Application for Planning Permission for Works or Extension to a Dwelling

Development: Erection of single storey front extension to create attached garage and installation of front porch canopy following the demolition of existing detached garage.
Location: 24 Elm Avenue East Preston BN16 1HL

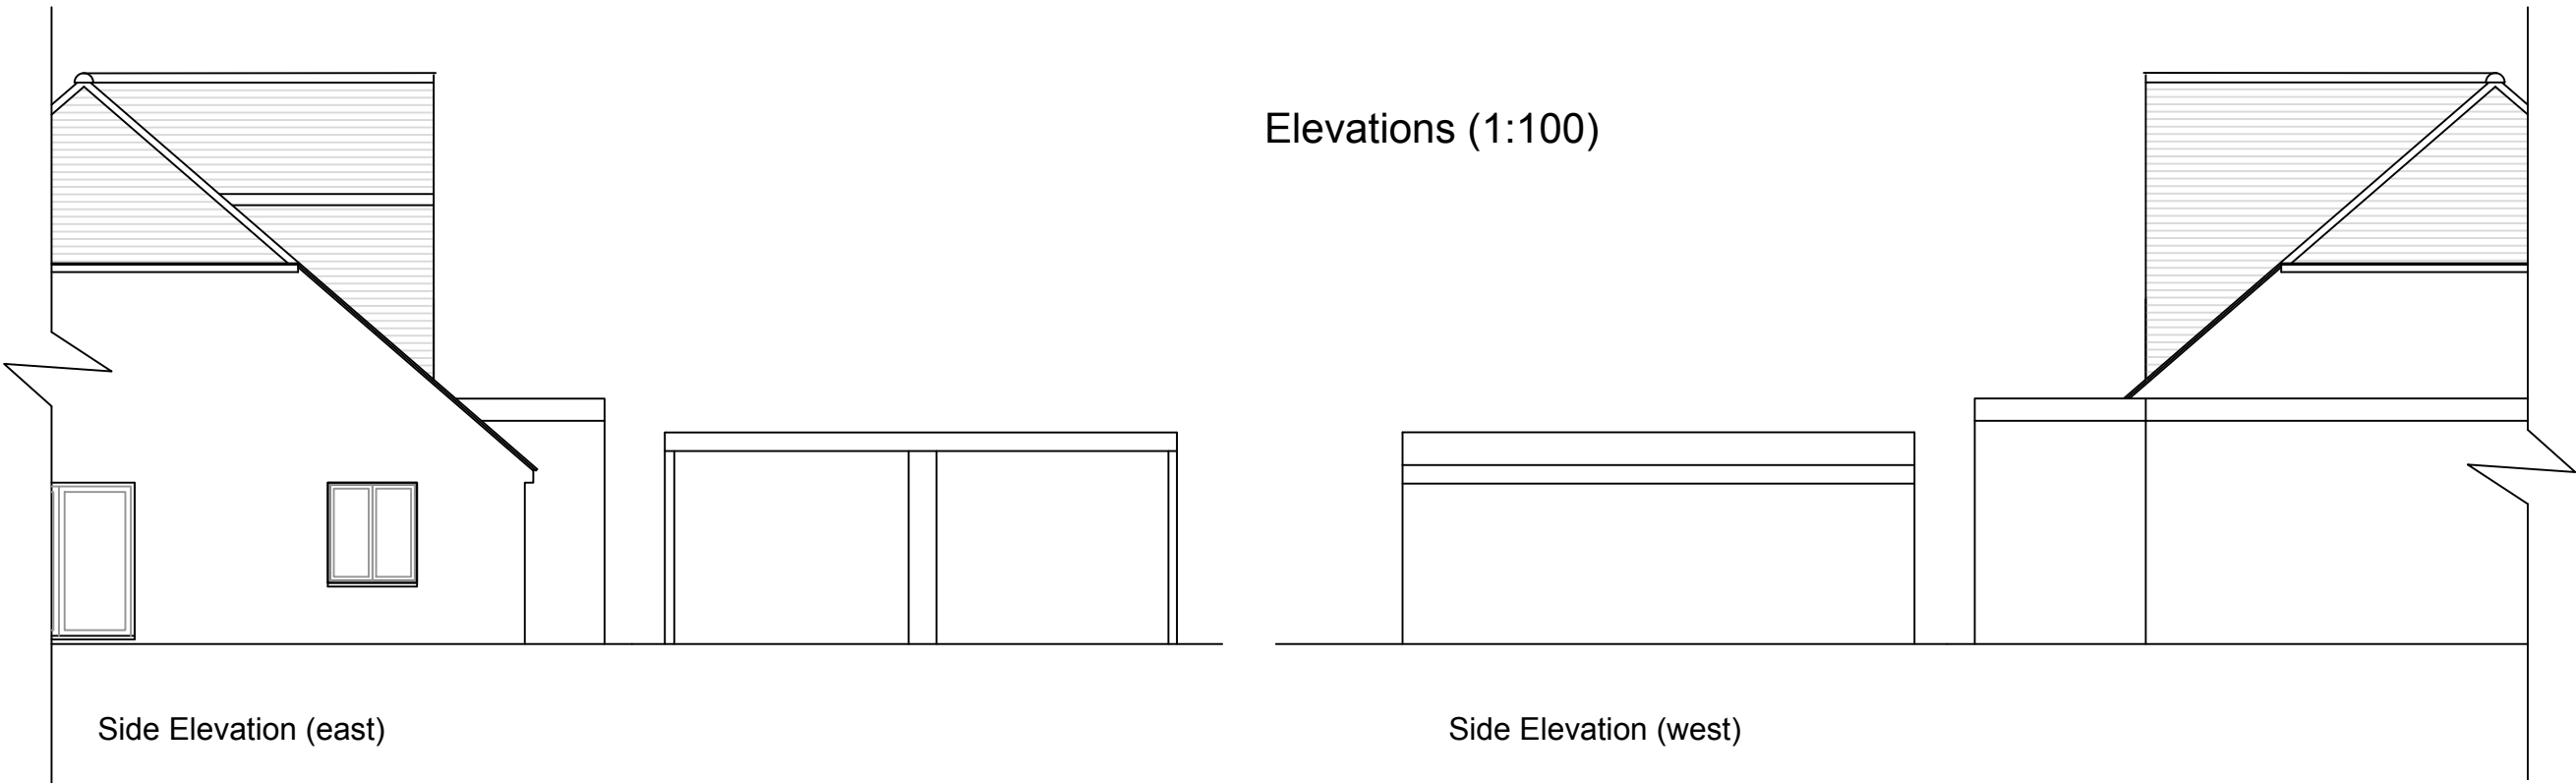
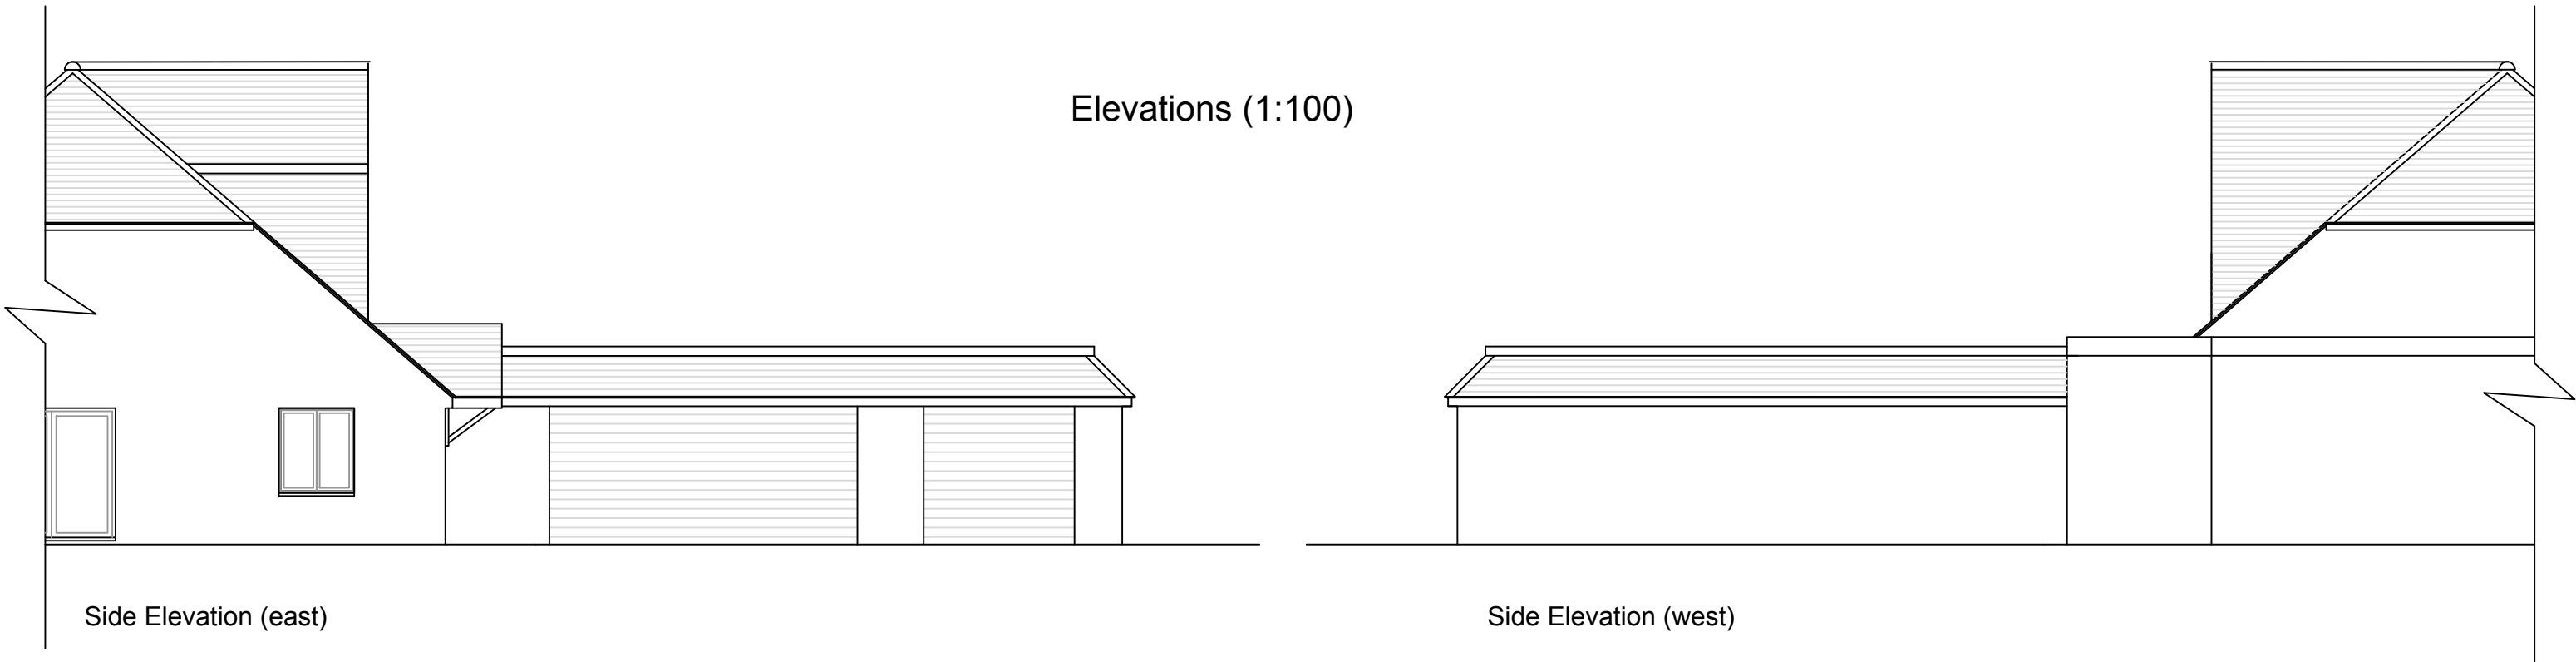
Plans: The living room windows on the ground floor plans are missing from the existing and proposed side elevations. Please review and amend.
